PLANNING AMENDMENT

Application No. 422/0441/01/A1
Date Registered 27 JUN 2002
Case Officer LS

EXTENSION TO EXISTING BUILDING

Amendment: Re-site building and carpark
Dwg.Nos. 1816/1D; /2D; /3C; /4A & /5A

DRG No. 1816/4^A

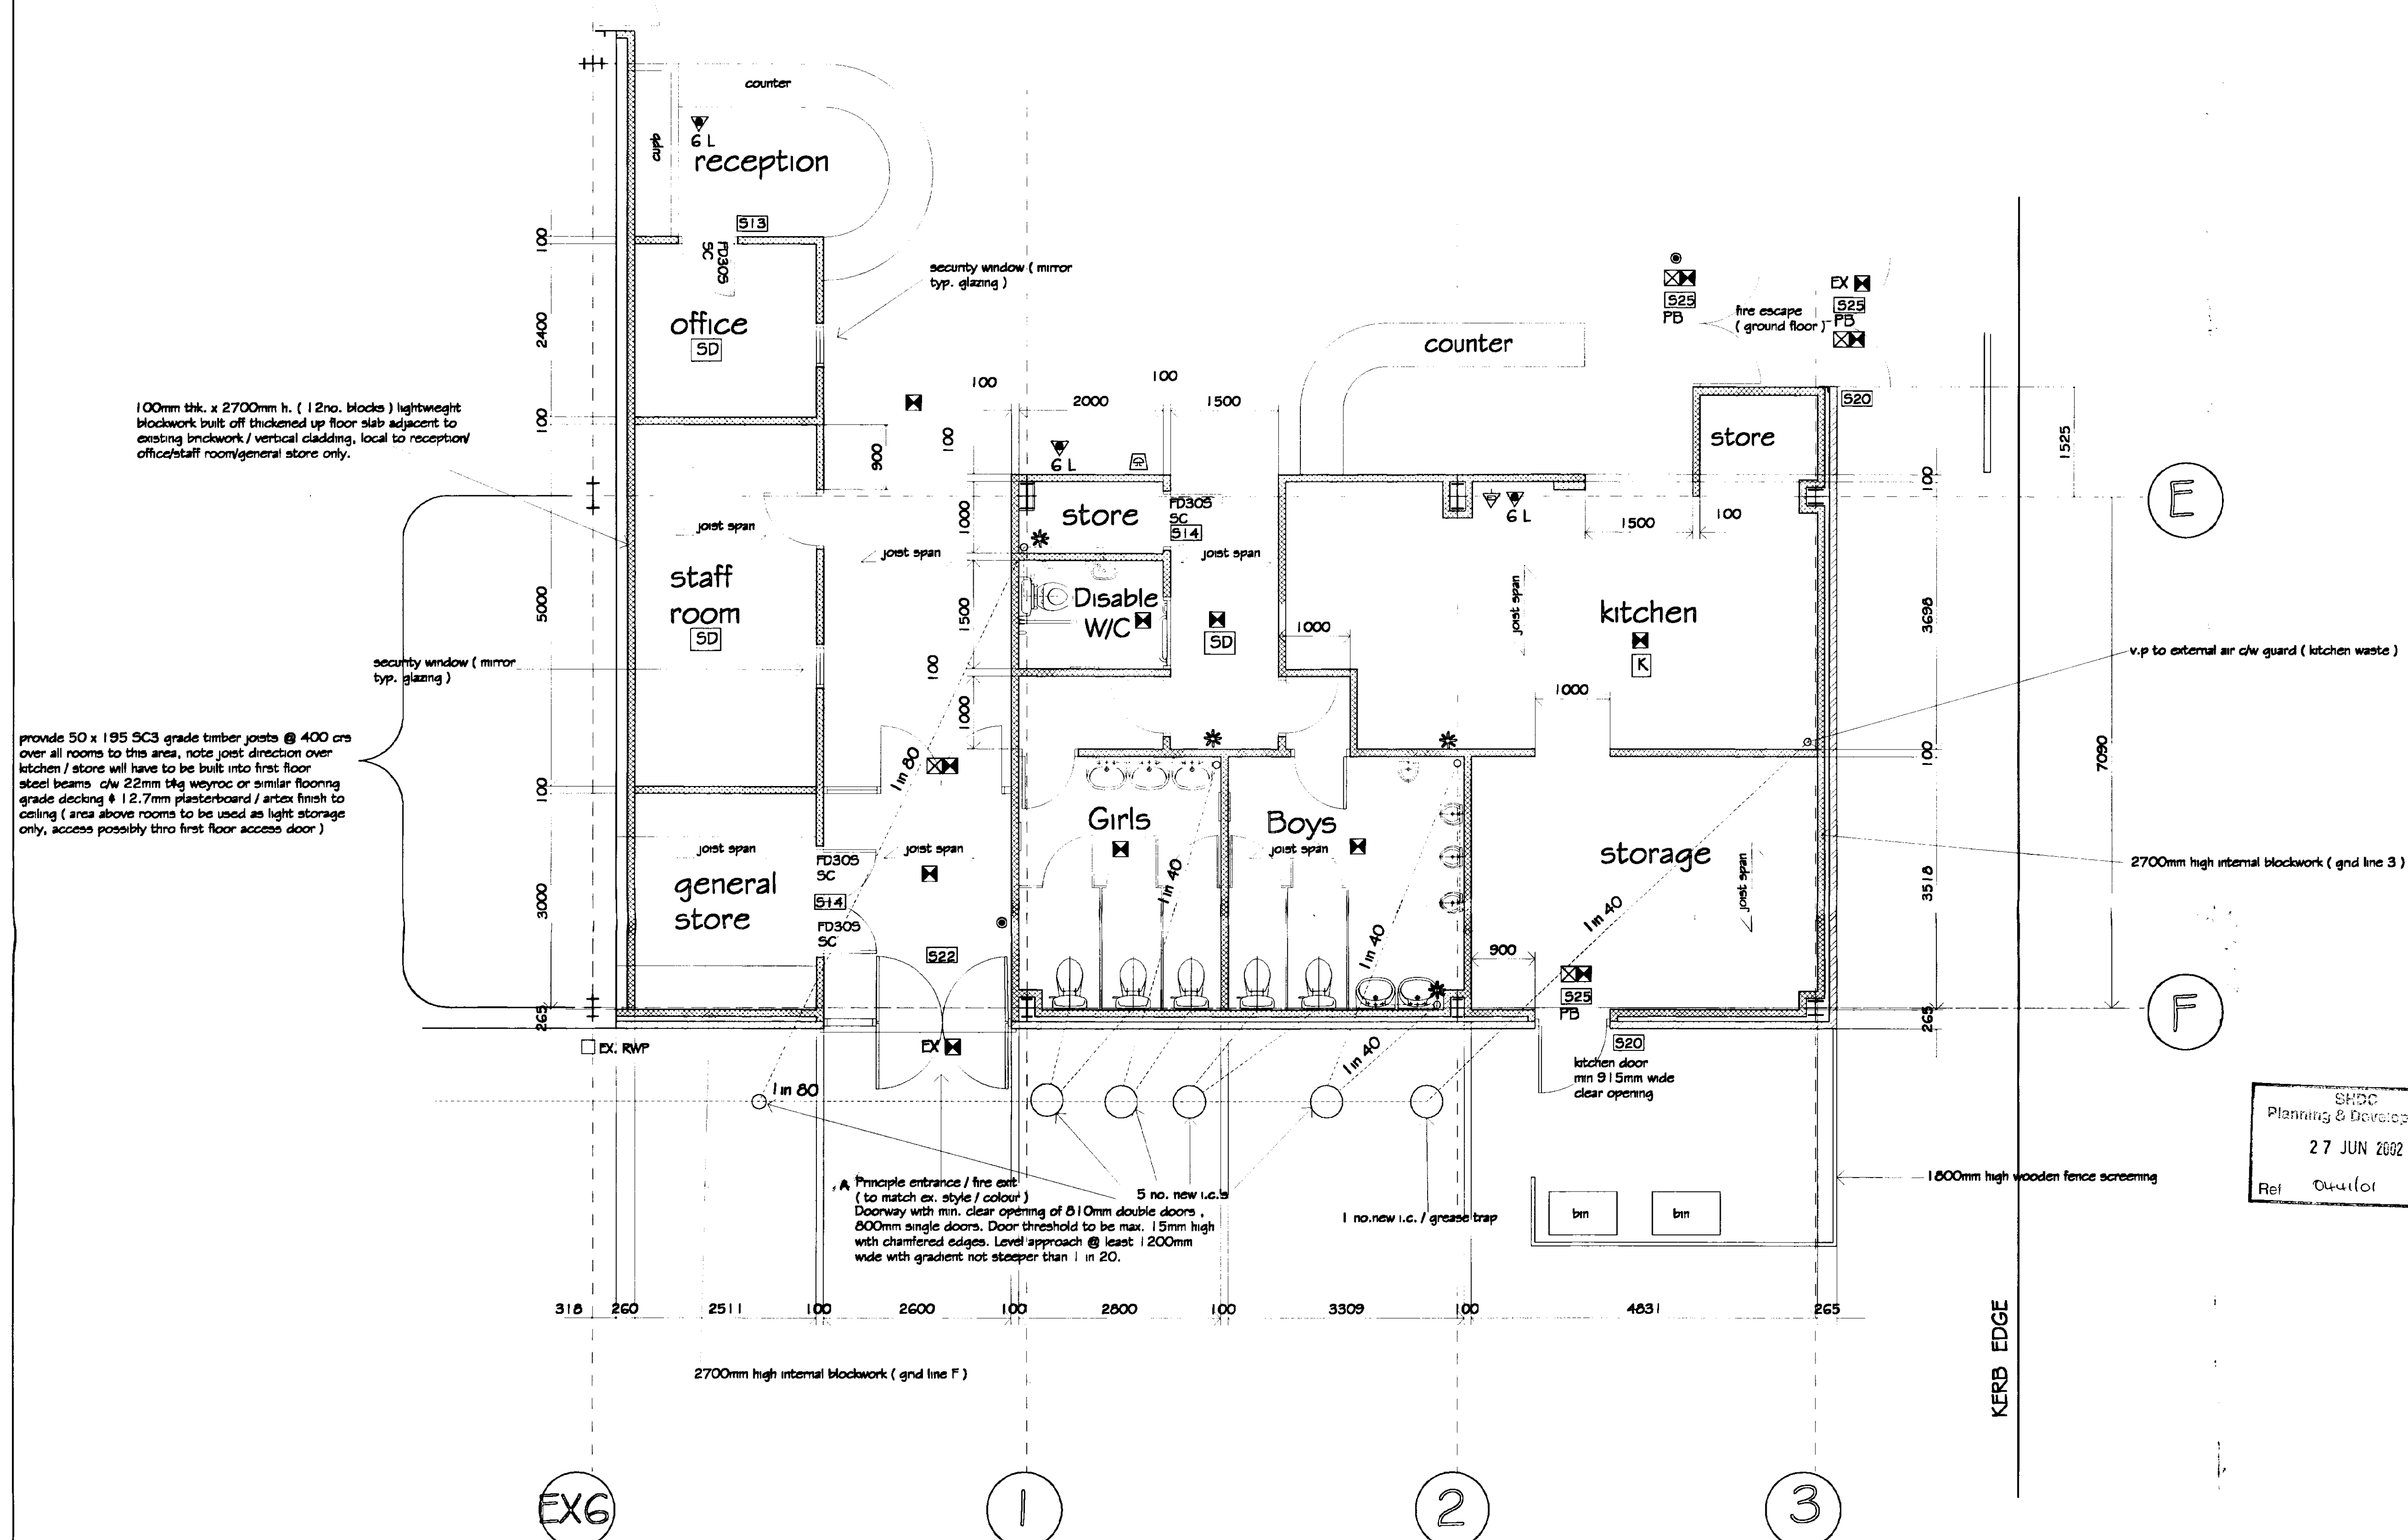
PRINCIPAL ENTRANCE DOOR GRID F REV. + DWG HT INCREASED LOCAL TO ABOVE. FIRE EXIT DOORS RE-POSITIONED INTERNAL GROUND & FIRST FLOOR LAYOUTS CONFIRMED.

DRG No. 1816/5^A

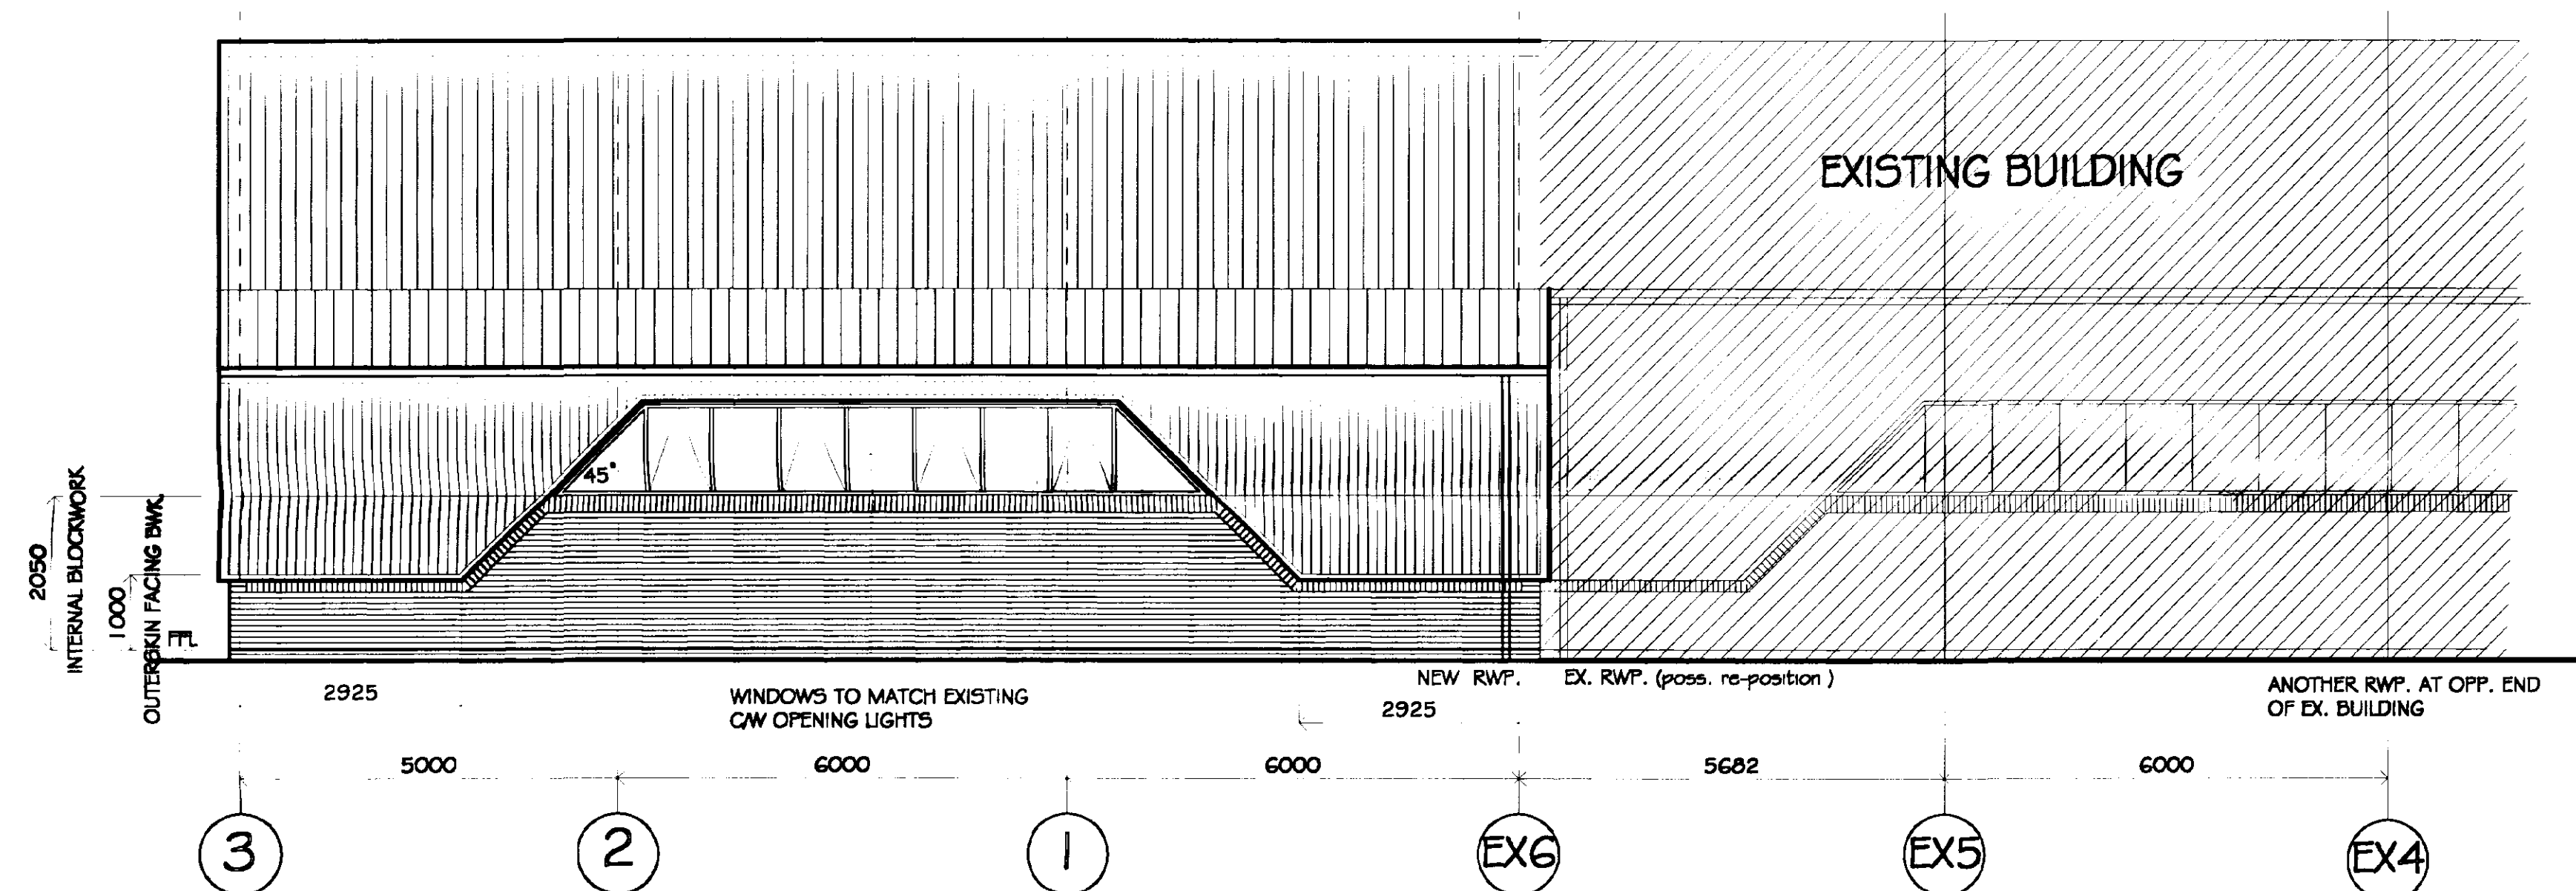
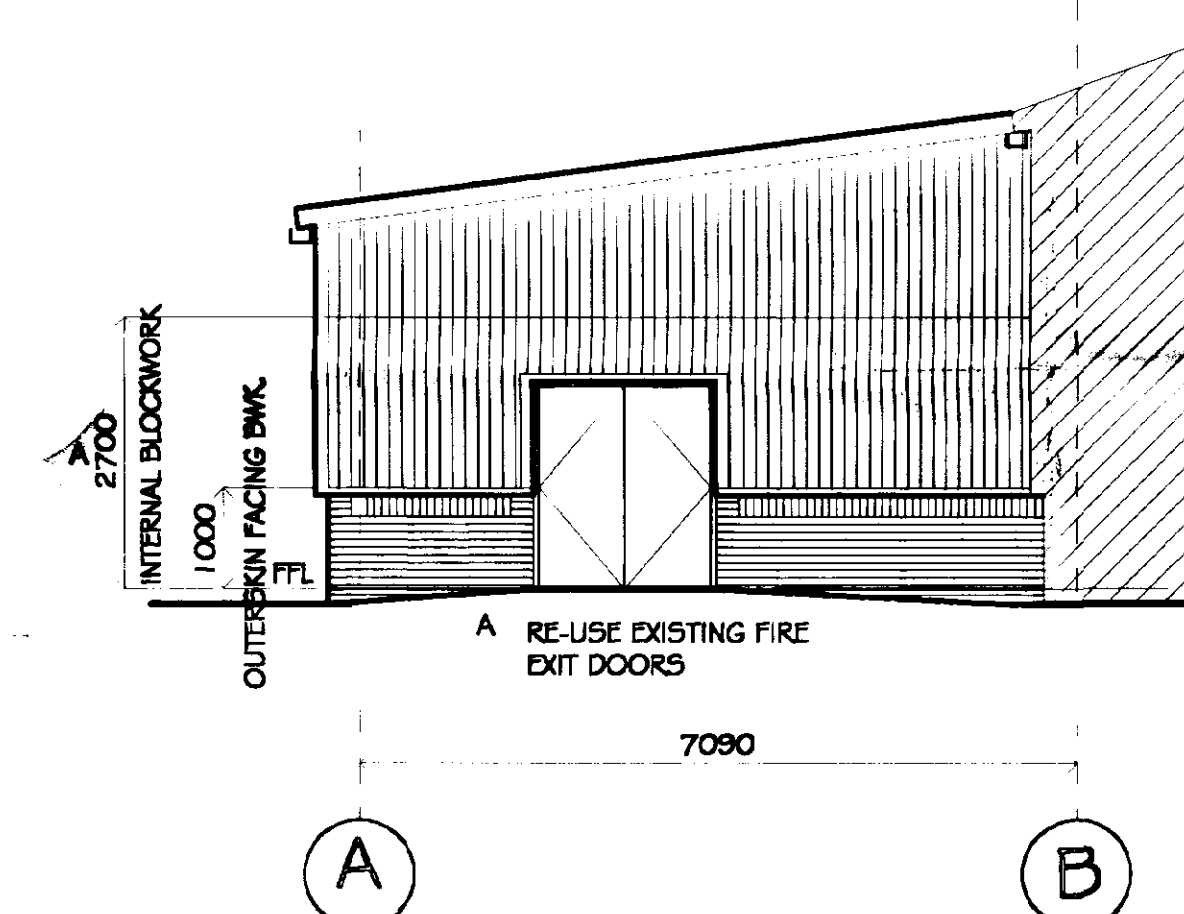
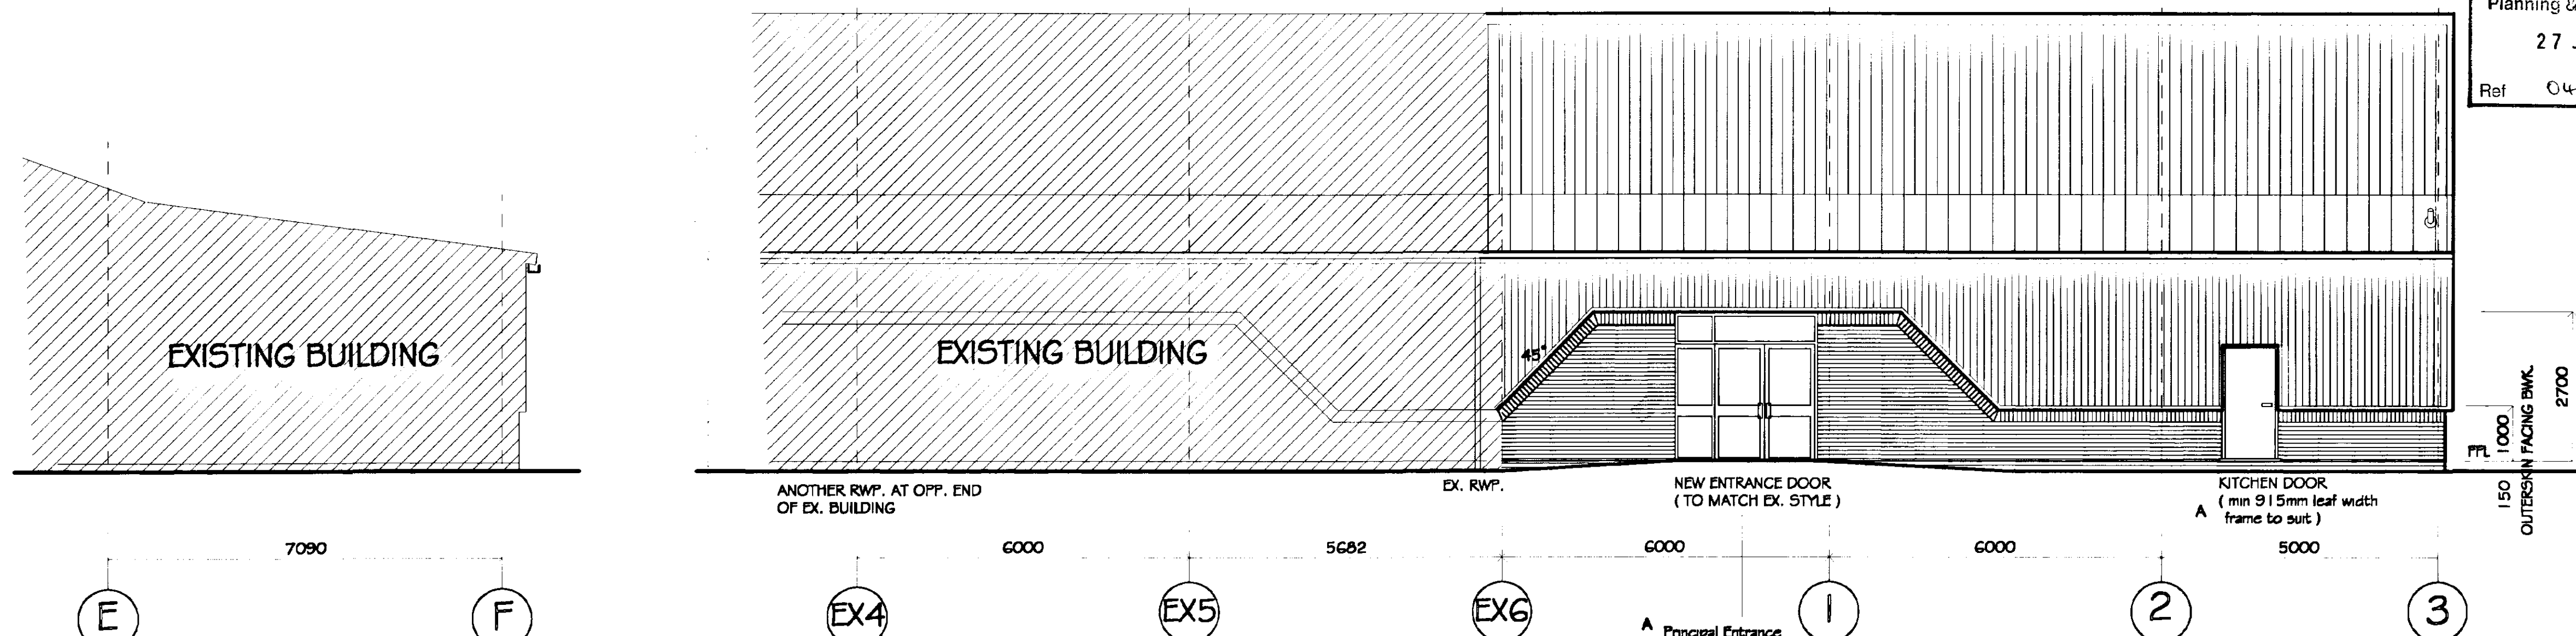
FIRE EXIT DOOR REMOVED FROM FRONT ELEVATION OF EX. BUILDING.
